KITTITAS COUNTY

DEPARTMENT OF PUBLIC WORKS

MEMORANDUM

TO: All Staff
FROM: Public Works Planning Review Team
DATE: March 3, 2021
SUBJECT: LPF-21-00001 The Pass Life at the Village at the Summit Div. 3, Phase 3 – CDS references this application as “Pass Life Origins”

**THE PASS LIFE AT THE VILLAGE AT THE SUMMIT, DIVISION 3, PHASE 3**  
 A PLANNED UNIT DEVELOPMENT  
 A PORTION OF THE SOUTH 1/2 OF SECTION 4,  
 TOWNSHIP 22 NORTH, RANGE 11 EAST, W.M., KITTITAS COUNTY, WASHINGTON

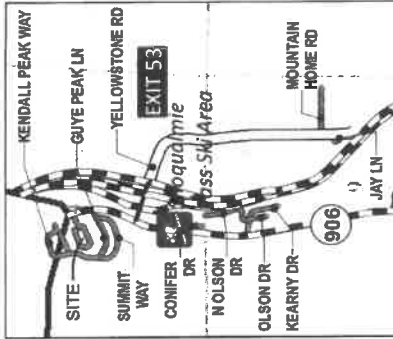
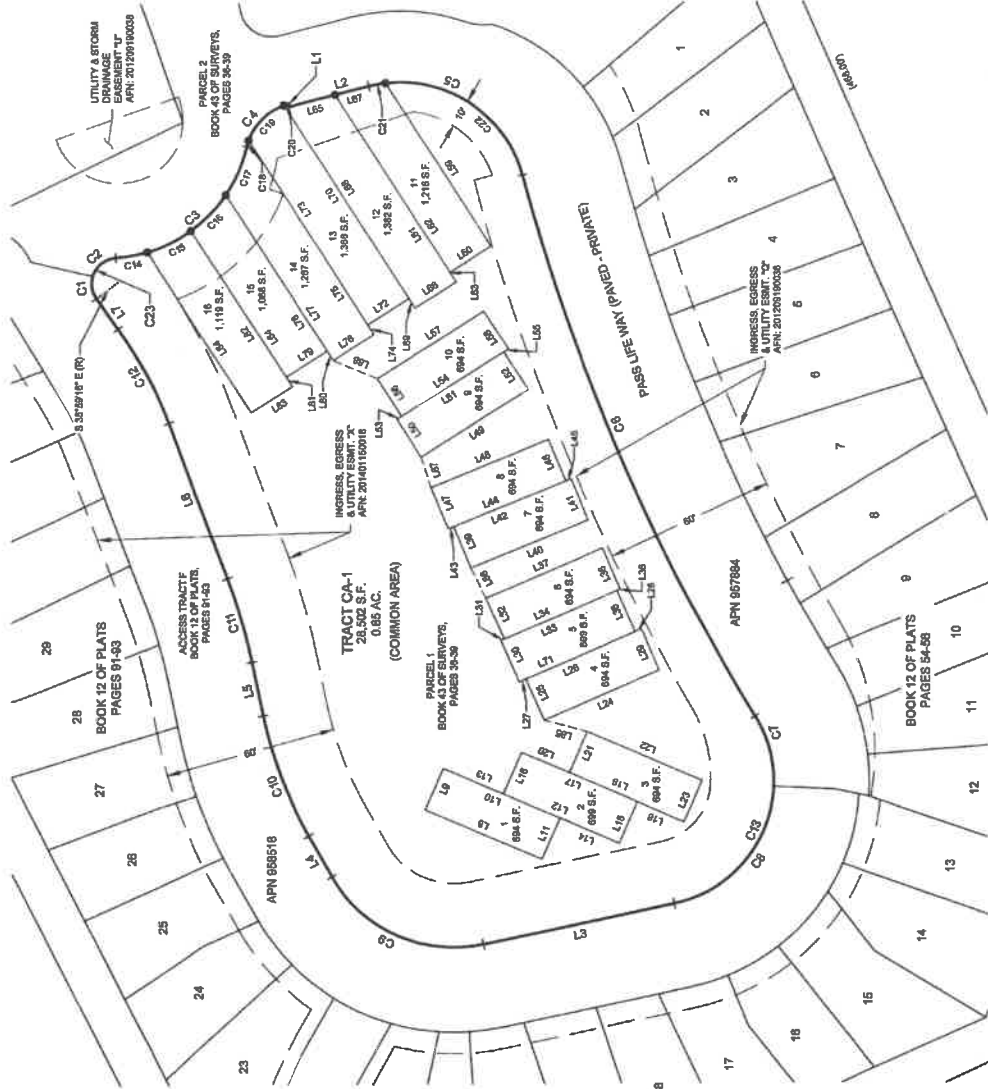
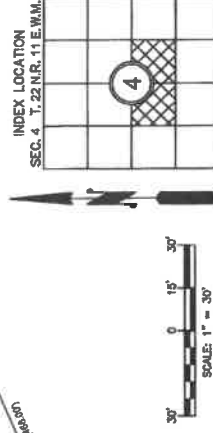
1. County Code calls for corners to be set at lot corners. The nature of this development makes that requirement unreasonable. While I believe ALL corners do not need to be referenced, I would like to see more than what is shown.

One option would be to set reference corners at the south extension lines of L8, L22, L24, L37, L40, L48 and L57, where the extension lines meet the outermost boundaries of Tract CA-1. This is just a suggested solution, not a requirement. I am open to discussing creative solutions to referencing the lot corners.

2. Note 14 references a Lot not clearly identified on the face of the Plat.
3. Please show the distance from the Easternmost point of the basis of bearing to the southernmost point of the line described as S23°30'10"E, 15.00’.
